2024/0317

41 Vernon Way, Gawber, Barnsley, S75 2NN

**Demolition of existing garage and erection of two-storey side and rear extension, conversion of existing loft to provide additional living accommodation and creation of new vehicular access.**

Drawing Title. PLANNING DRAWING PLANS & ELEVATIONS			Date. MARCH 2024	Scale. AS INDICATED																																																													
Ref. 105-21			Dwg. No. P01	Rev. A

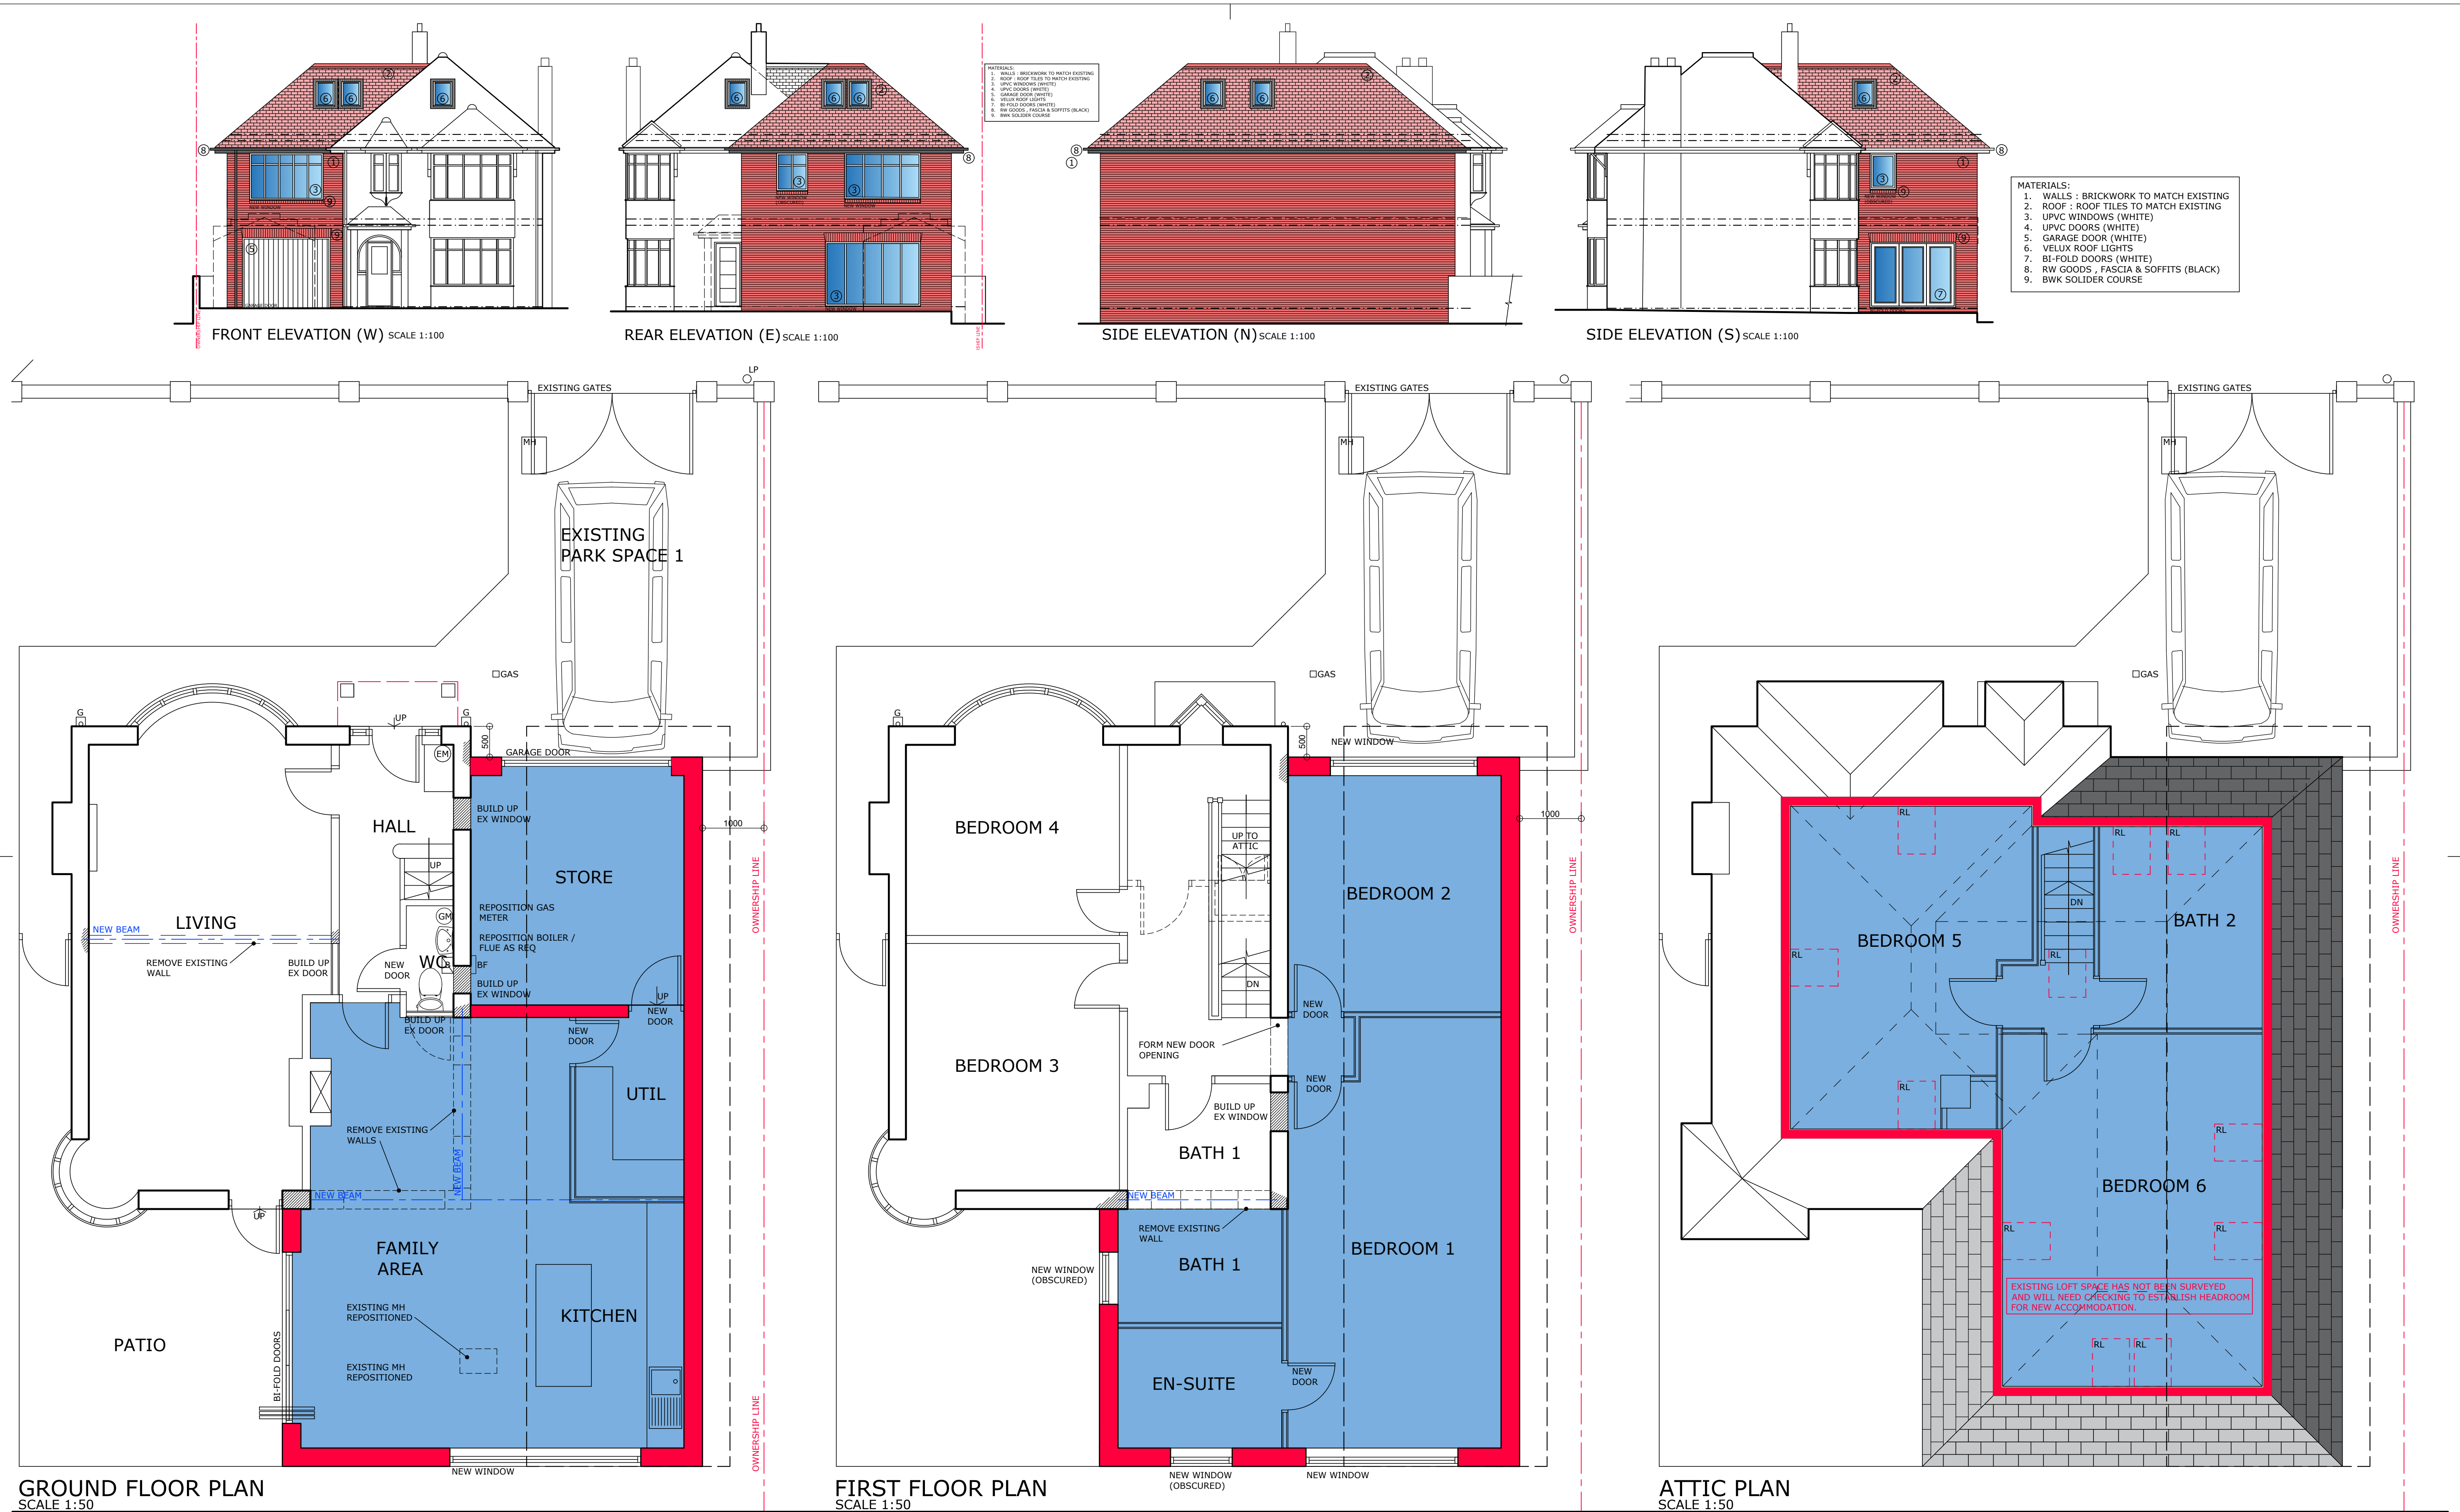
During the application process, the proposal was amended to set the extension further back from the main front wall of the application property and further in from the north boundary to comply with the House Extensions and Other Domestic Alterations SPD and to address concerns raised in relation to overshadowing.

During the application process, concerns were raised in relation to overshadowing and enclosure in that the height and proximity of the extension would overshadow the outside space between the application property and 40 Vernon Way and impact the neighbouring garden and side-facing windows which serve a kitchen, bedroom, bathroom and hall.

During the application process, concerns were raised in relation to loss of privacy in that the windows to the rear of the proposed extension would appear large and would be located close to the north boundary and would overlook the rear garden of 40 Vernon Way.

New first-floor windows would be limited to the front, rear and south side elevations of the proposed extension. No windows would be located on the north side elevation. The House Extensions and Other Domestic Alterations SPD states that 12 metres should be maintained to a blank gable wall and 10 metres should be provided between rear-facing windows on the first floor (and above) and the rear boundary, and 21 metres should be maintained between habitable room windows on an extended property and those on a neighbouring property. In this instance, approximately 13 metres would be maintained to the rear boundary with no buildings with habitable room windows beyond. A

The glazing located on the south side elevation of the proposed extension would face towards the rear curtilage of 49 Vernon Way where low-level boundary treatments on the south boundary could enable some overlooking and loss of privacy. However, a two-metre-high fence could be erected under permitted development (therefore not requiring planning permission) if needed and the proposal shows that the first-floor window would serve a non-habitable room (bathroom) and would be obscure glazed. A first-floor window to the rear elevation serving an en-suite would also be obscure glazed. For the avoidance of doubt and to maintain the amenity of the occupant(s) of the application and neighbouring properties, a condition will be attached to any forthcoming decision to require these windows to be obscure glazed.

In this instance, the proposed extension would not adopt an excessive sideways projection more than two thirds the width of the original dwelling, would be set back from the main front wall of the application dwelling by approximately 0.5 metres and would be set in from the north boundary by approximately one metre, in accordance with the House Extensions and Other Domestic Alterations SPD. The proposed extension would adopt a sympathetic form and features, including a hipped roof
